East Anglia TWO Offshore Wind Farm

Appendix F1b to the Natural England Deadline 1 Submission

**Comments to the Applicant Comments on Natural England's Relevant and Written
Representations [AS-036] All Other Matters**

2nd November 2020

Drawing file: published-documents / EN010078-001116-6.2.10.14 EA2 ES Figure 10.14 Herring Spawning and Nursery Grounds.pdf

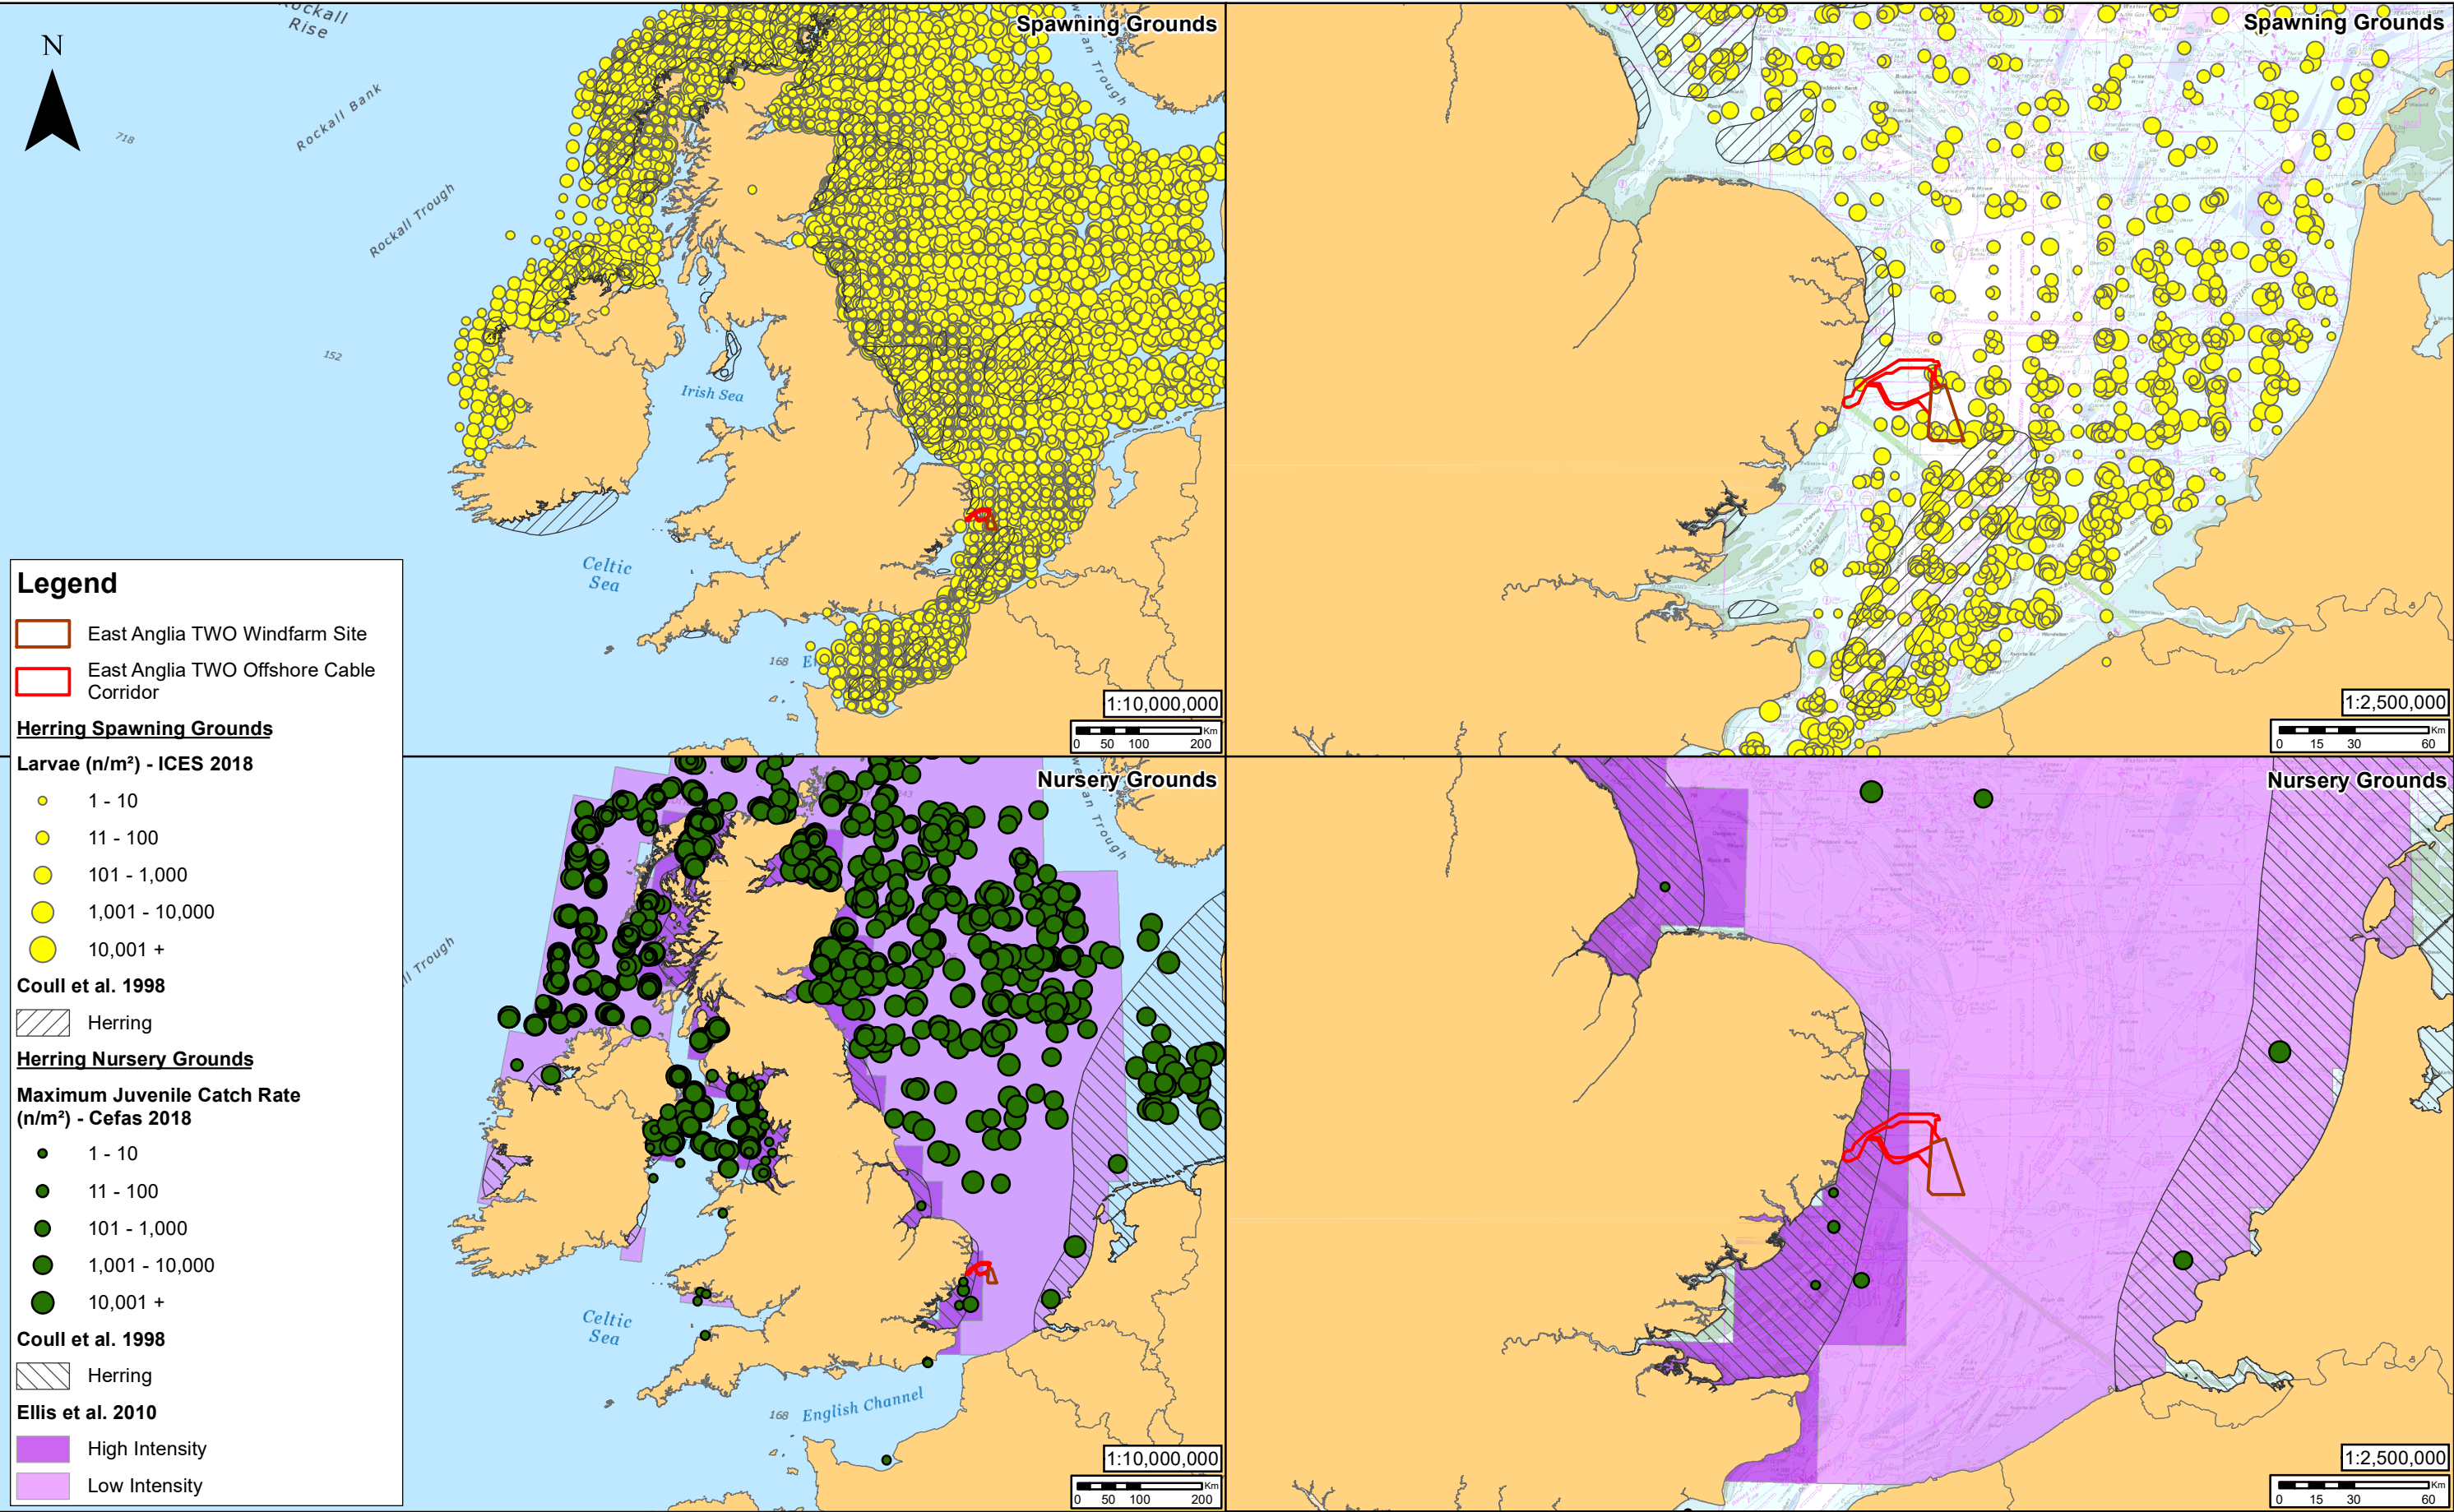
4.2.3	<p>With regards to sand eels and their limited capacity to flee, Figure 10.14 highlights the site sits within the nursery and spawning grounds as defined by Coull et al. 1998 and low intensity nursery grounds as identified by Ellis et al. 2010. Is there any further site specific information to determine the likelihood of being in direct contact with sand eel habitat and linking this to the noise modelling impacts to have a greater understanding of the risk given to sand eels?</p>	<p>As described in section 10.2.4.3 in Appendix 10.2 (APP-463), Particle Size Analysis (PSA) data from benthic surveys undertaken across the former East Anglia Zone were analysed to provide an indication of the suitability of the offshore development area in terms of potential for provision of habitat for sandeel. This is shown in Figure 10.2.4 of Appendix 10.2. As expected, given the sandy nature of the sediment across the offshore development area, preferred and marginal sandeel habitat was identified, with unsuitable areas identified at discrete locations particularly along the offshore cable corridor. It should be noted, however, that the habitat classification on which this analysis is based (Marine Space, 2013)⁵⁶ relies on sediment composition rather than evidence of sandeel</p>	<p>Natural England notes the further detail provided by the applicant regarding sand eel habitat and sensitivity to noise impacts, however, we defer to Cefas for their expertise on this topic.</p>

<p>usage of the area.</p> <p>This is further supported by Jensen et al. (2011)57 and Figure 10.26 of the ES (APP-154) which shows that the main sandeel habitats do not overlap with the offshore development area. The presence of suitable sediment does not necessarily imply that sandeels are present or that a given area would ever be colonised by sandeels. Figure 10.41 (APP-169) and Figure 10.3.8 of Appendix 10.3 (APP-464) display the noise impact ranges against sandeel nursery and spawning groups for both the fleeing and stationary animal model respectively. As discussed in section 13.5.6.1 of Chapter 13 Commercial Fisheries (APP-059), analysis of VMS data for the sandeel fleet (Figure 13.37 (APP-218)) suggests that activity by sandeel industrial trawlers is mainly concentrated in areas such as the Dogger Bank (Central North Sea) and the Norwegian coast (Northern North Sea). Although not restricted to these areas activity is considerably lower in the Southern North Sea. In the offshore development area activity by these vessels occurs at negligible levels therefore it is very likely that there is a</p>
